City of Albuquerque

January 28, 1983

RE: DRAINAGE PLAN FOR ALBUQUERQUE NATIONAL PARK OPERATIONS CENTER

C-1

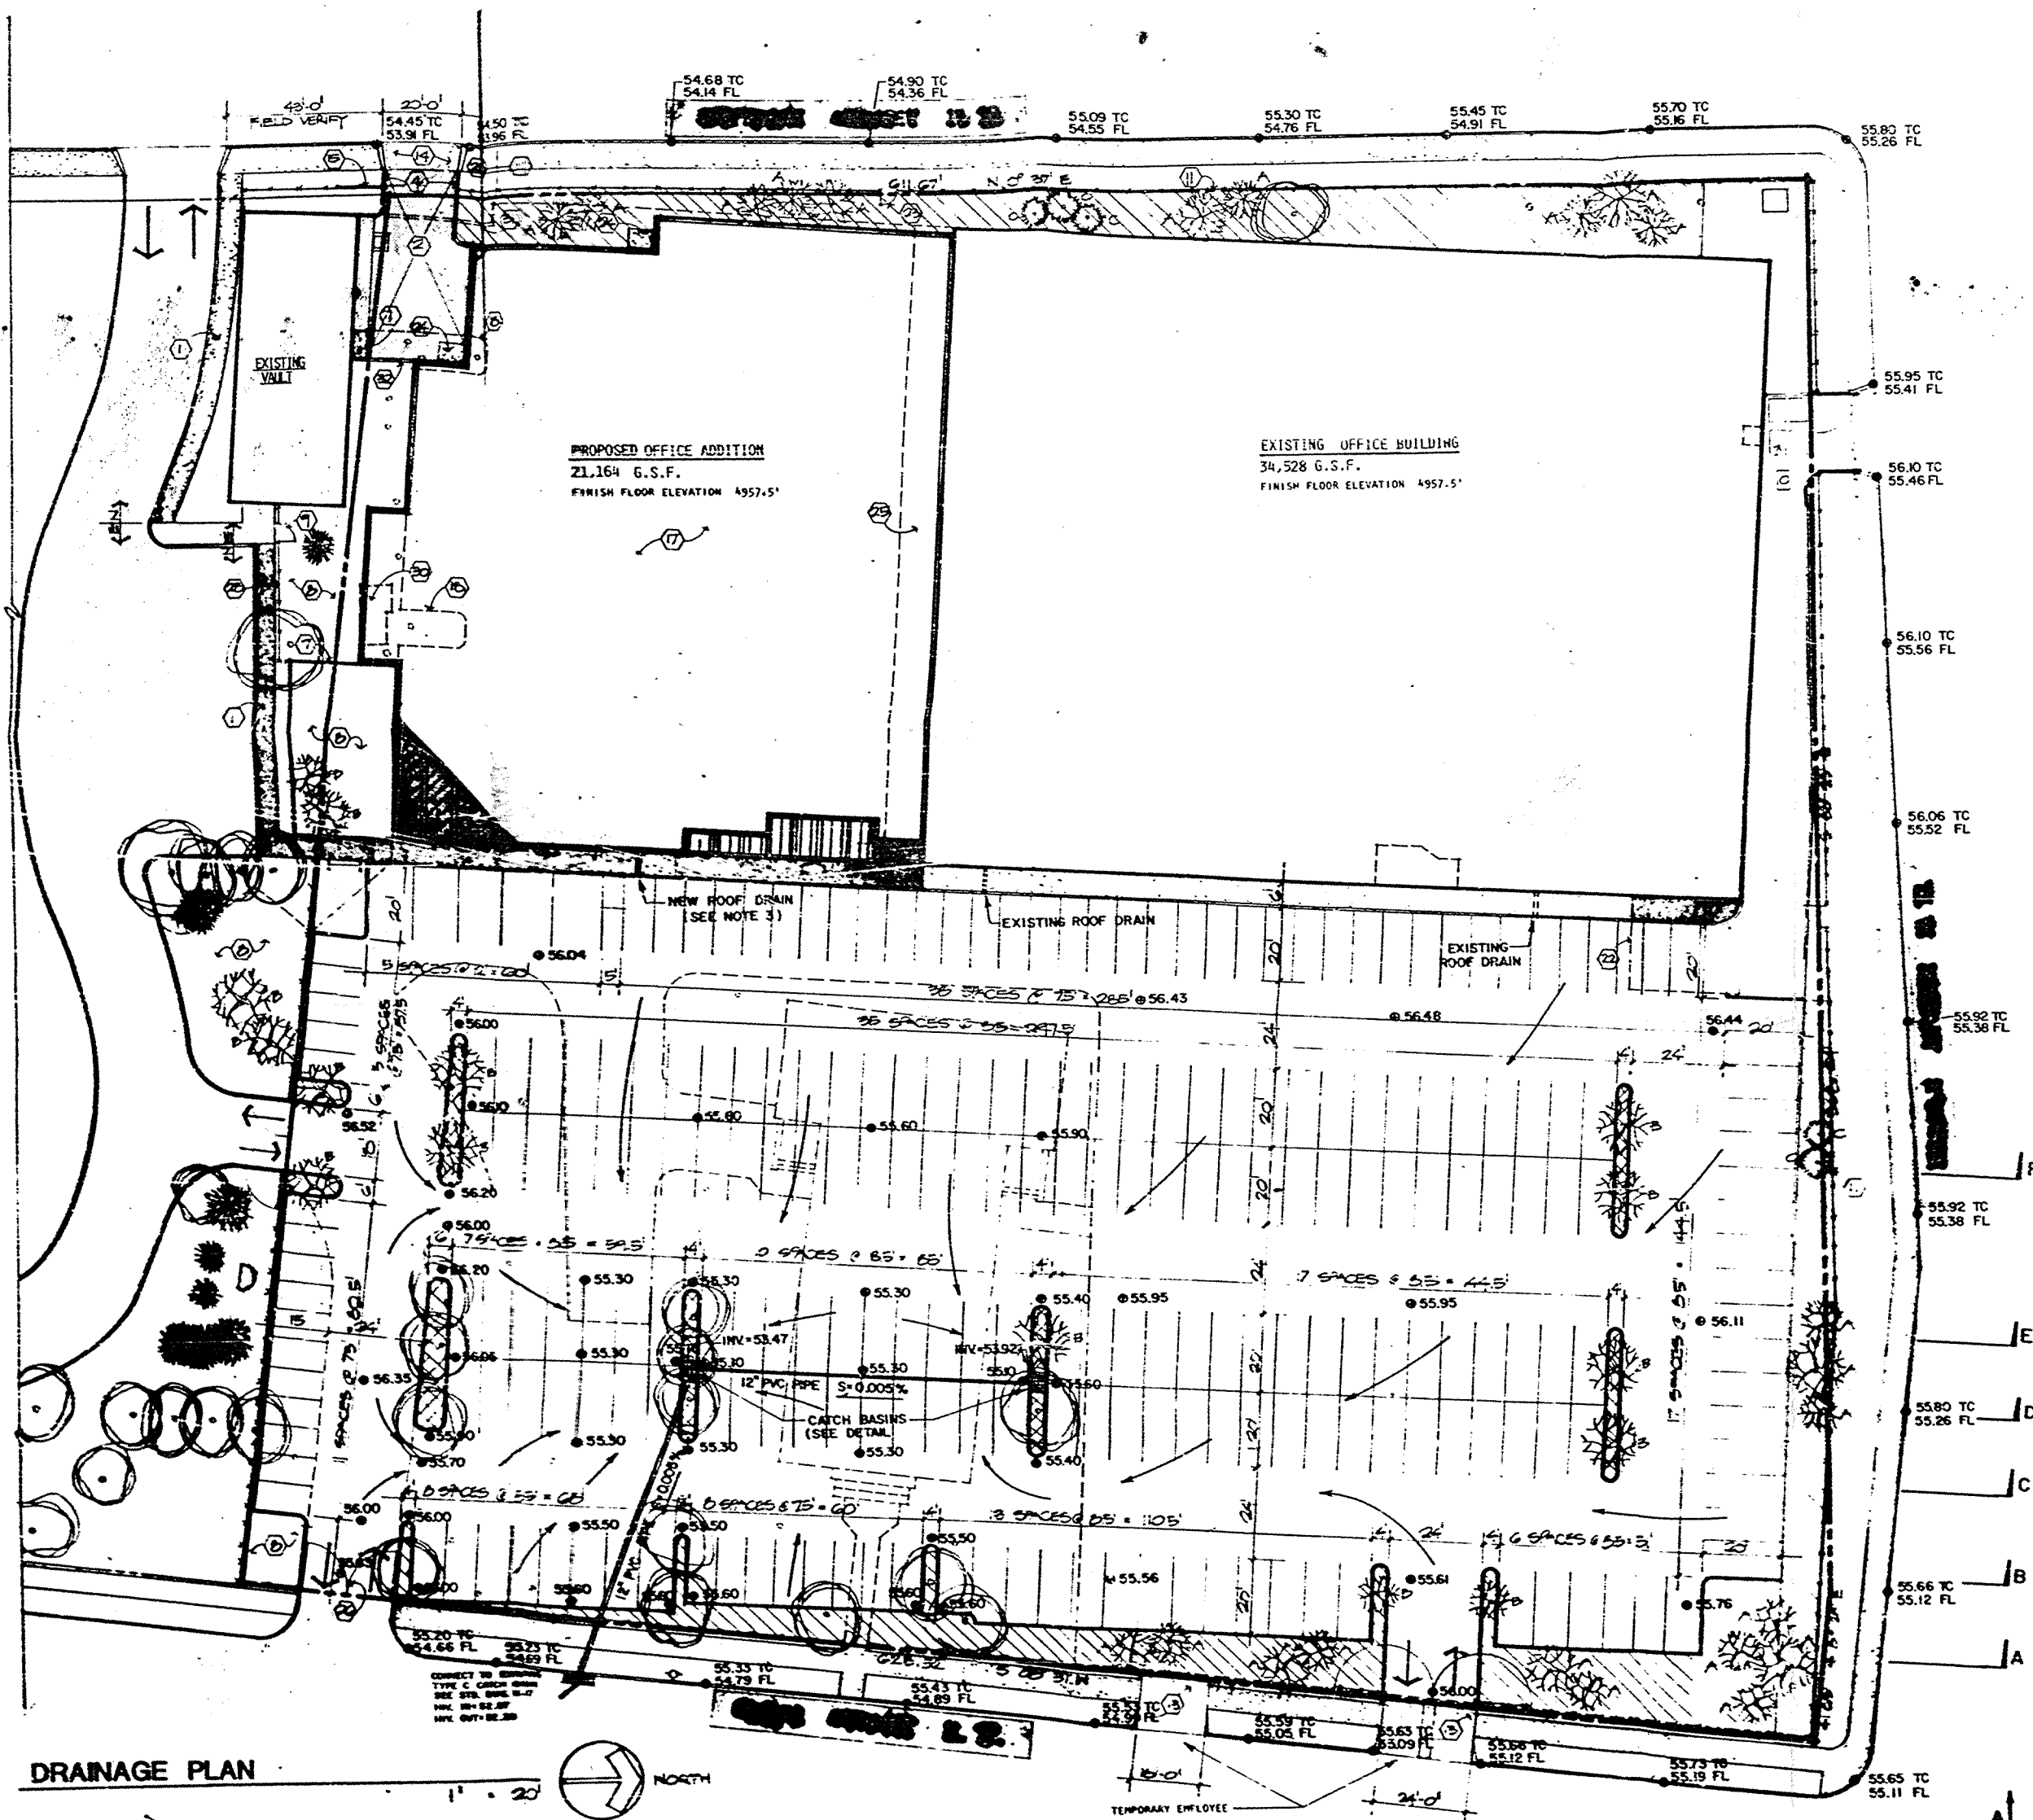
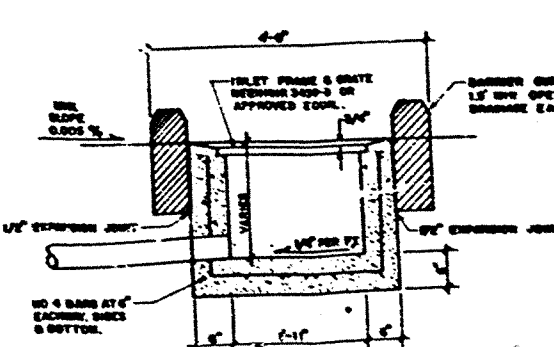
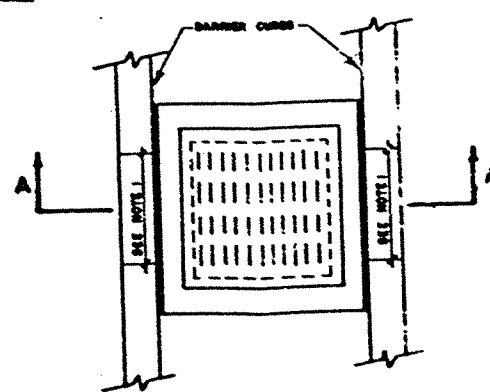
1. Please identify the 100-year ponding limit on the plan.
2. Please call out the orifice plate on Section A-A of the Catch Basin detail.
3. Can the finished floor elevation of the existing building be used as a temporary bench mark?
4. Approved copies of Special Order No. 19 for the storm drain connection must be placed in the City construction sets prior to release of the building permit.
